Application No: M/71/20/HH
Site Address: 18 Sea Way Elmer Middleton-On-Sea PO22 6JY
Description of works: Construction of first floor dormer to provide enlarged bathroom and wardrobe/storage, construction of detached garage

Thank you for your internet representation made on 20th October 2020 which has been recorded as an objection with the comments as follows:

CLIENT
MR AND MRS PRYOR
PROJECT
ALTERATIONS AND EXTENSIONS
18 SEA WAY, ELMER SANDS
BOGNOR REGIS, PO22 6JY
DRAWING TITLE
PROPOSED SECTION AND ELEVATIONS
DORMER BATHROOM EXTENSION
SCALE
1/50 and 1/100 at A3
REFERENCE
11521.15

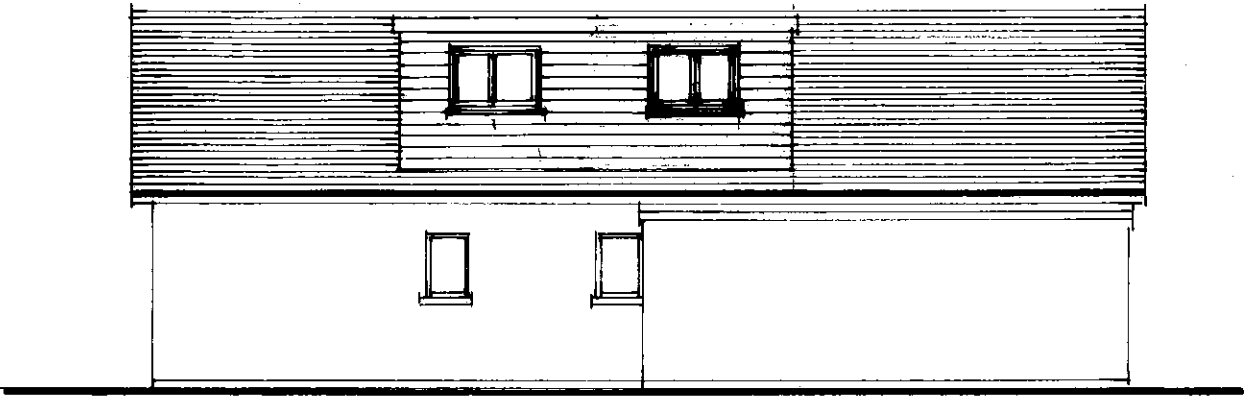
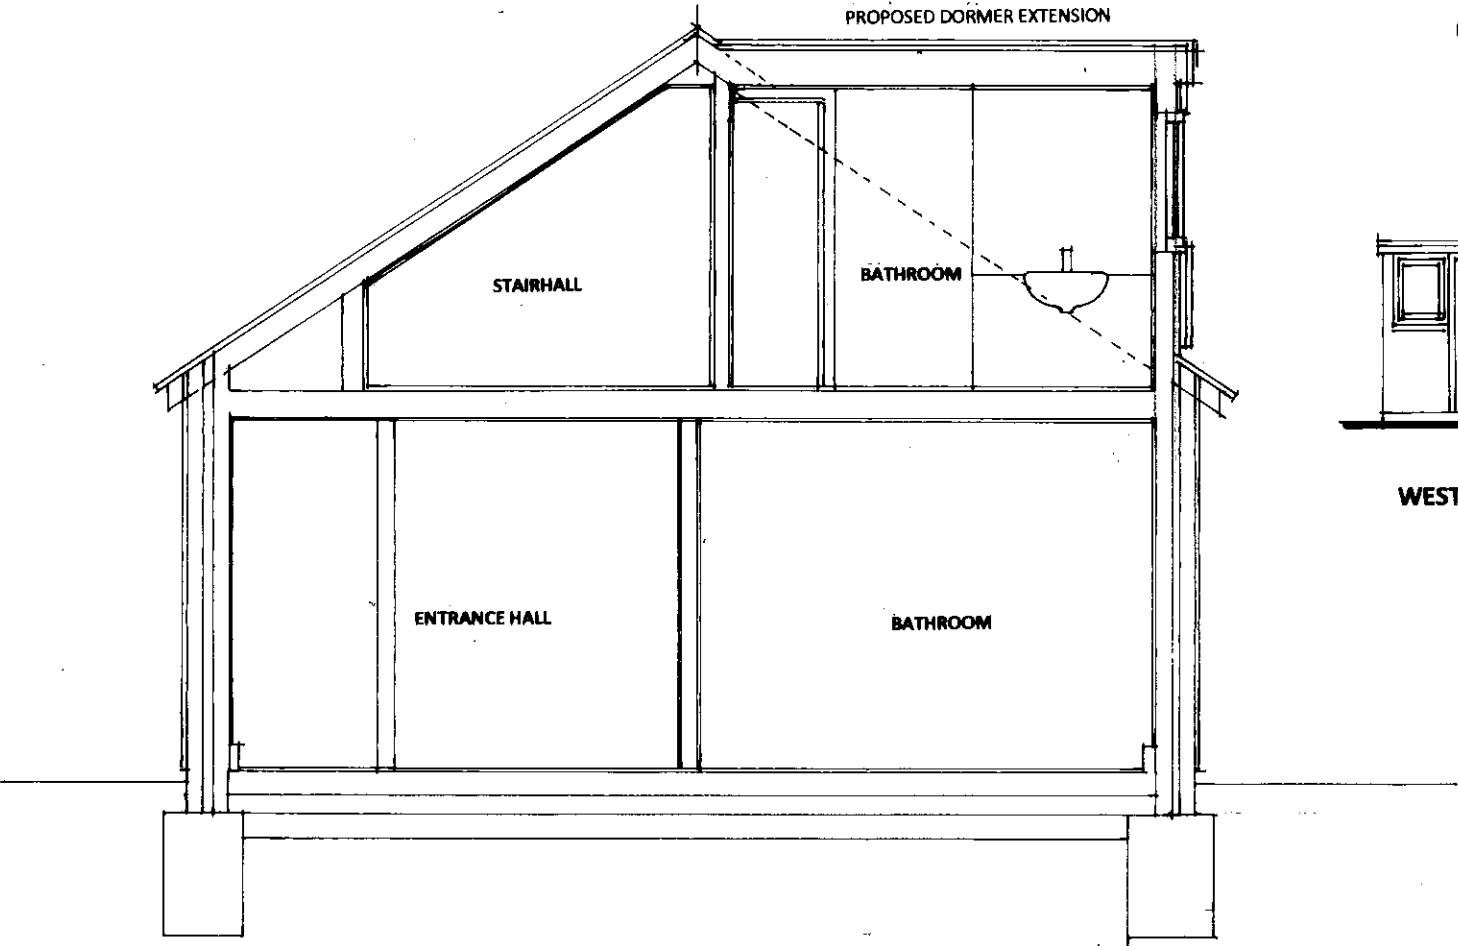
The small cottage which has submitted this planning application was extended in the last few years adding a third to their existing footprint and they have little garden space left; on examination of this application this development is in close proximity with the bungalow to the north which it would impact severely and the bungalow to the south. The proposed development would overshadow , impact on natural light and would be overdevelopment between the two small bungalows to each side of the site.

DRAWING TITLE
**PROPOSED DETACHED GARAGE
FLOOR PLAN AND ELEVATIONS**

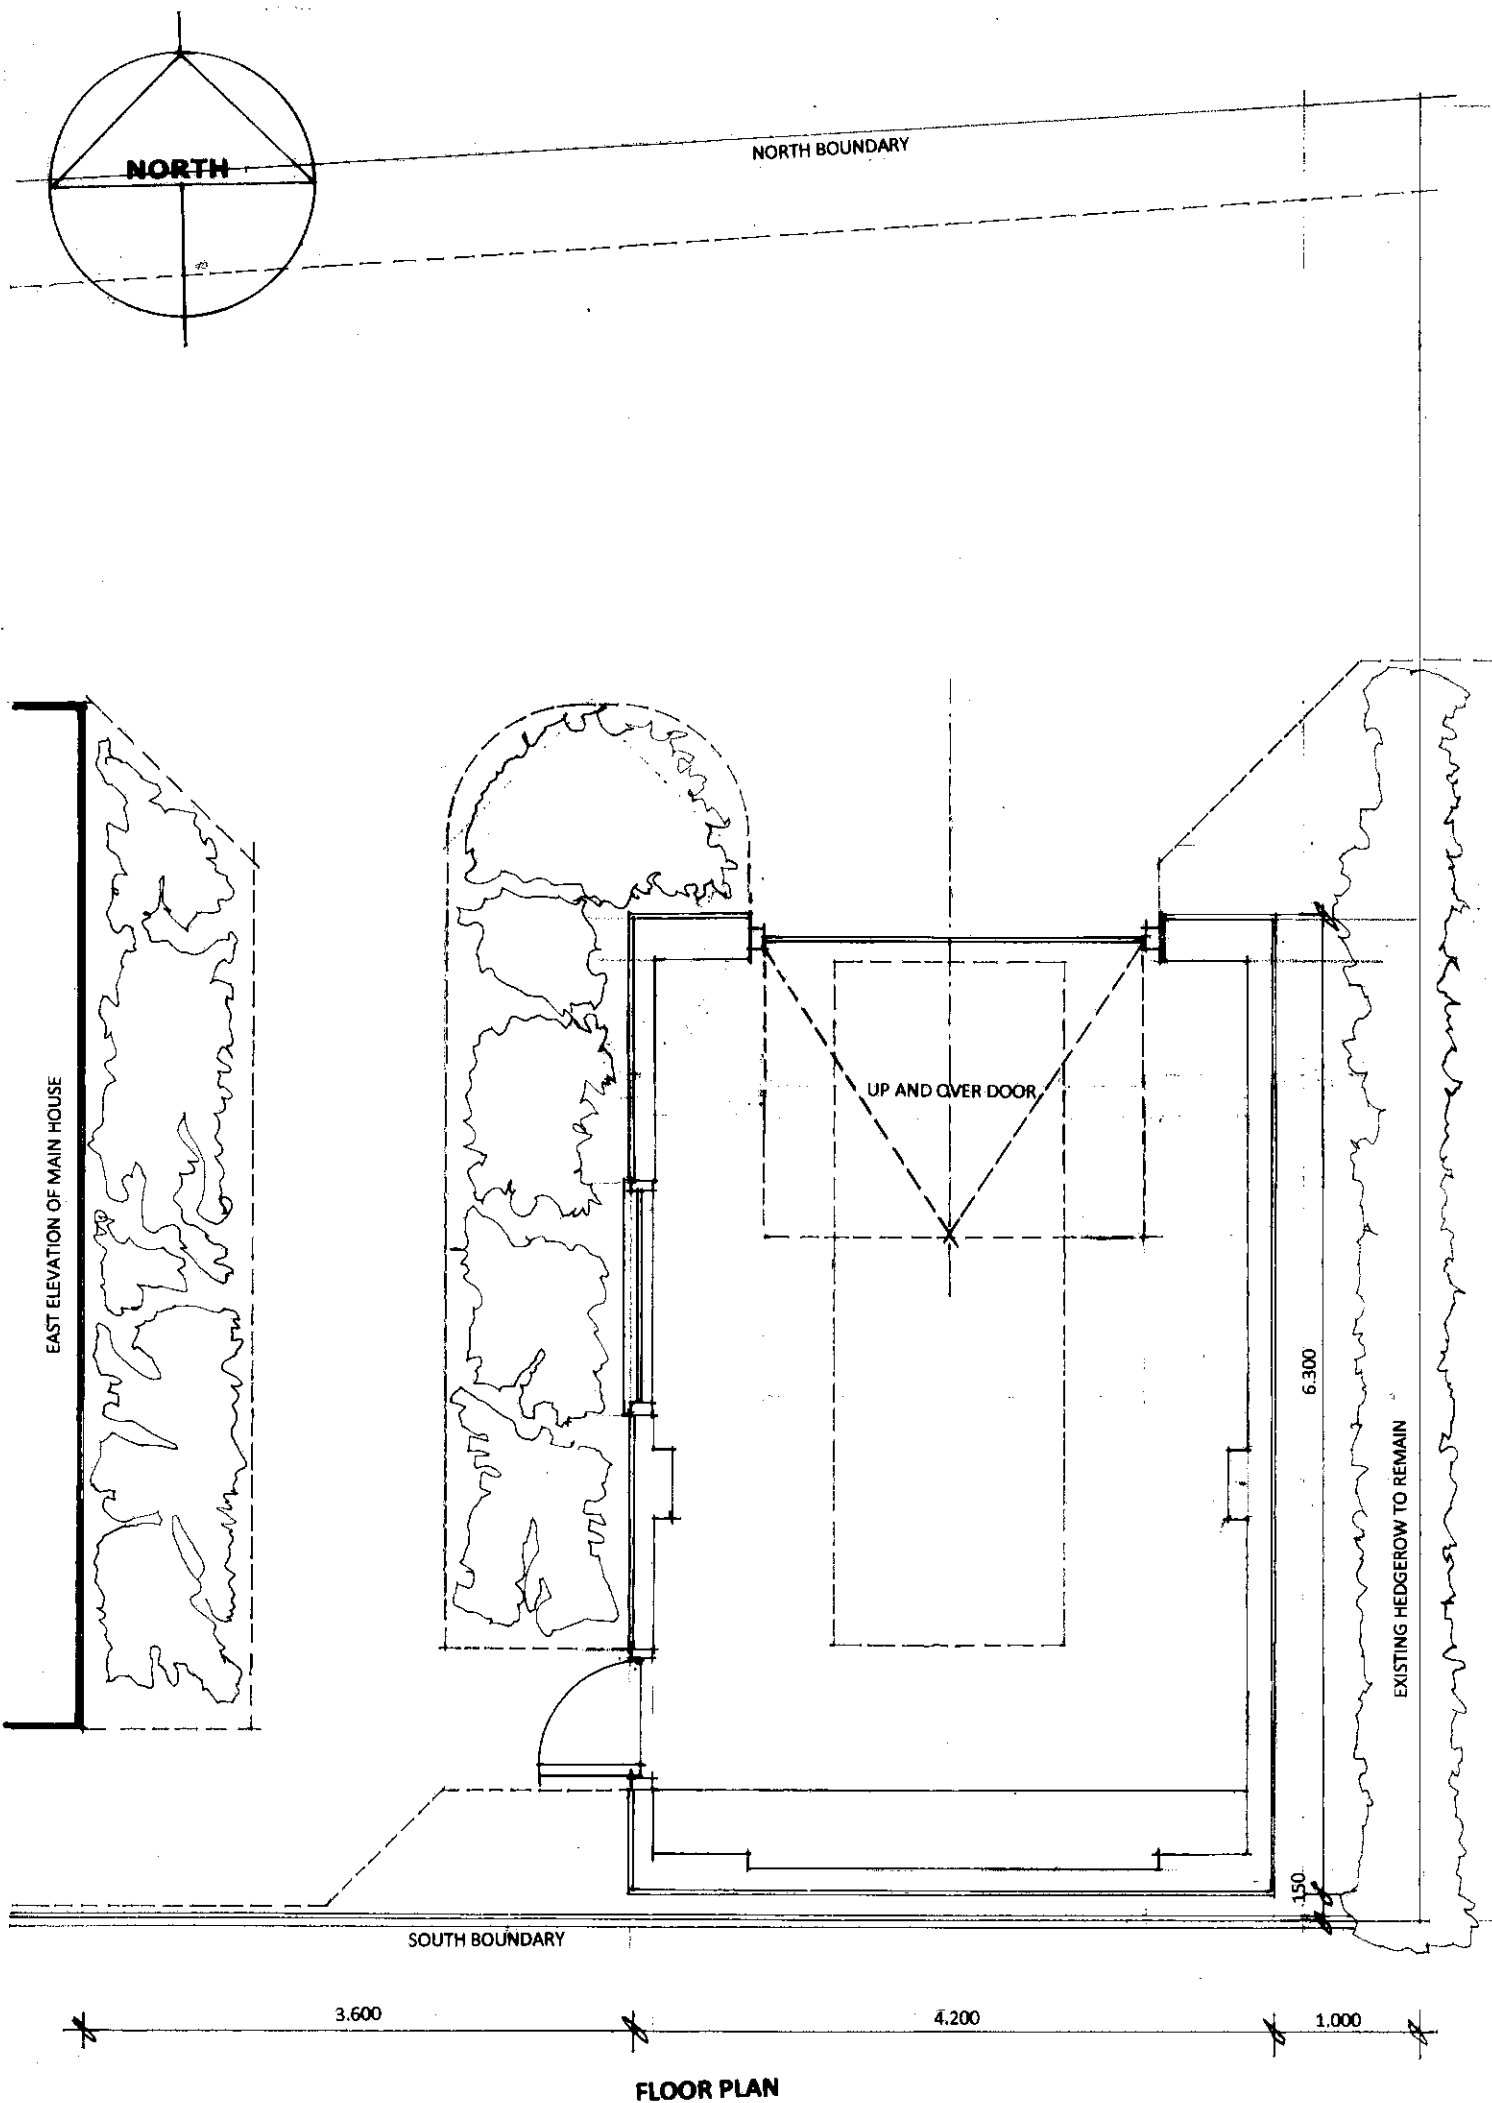
The proposed location of the large additional detached garage would involve a significant loss of garden land which will eliminate the open aspect of the space and would also constitute an over-development of the site. The loss of amenity green space would visually impact all properties including mine that overlook and would have a negative adverse visual impact on the landscape, the immediate neighbouring residences and the locality.
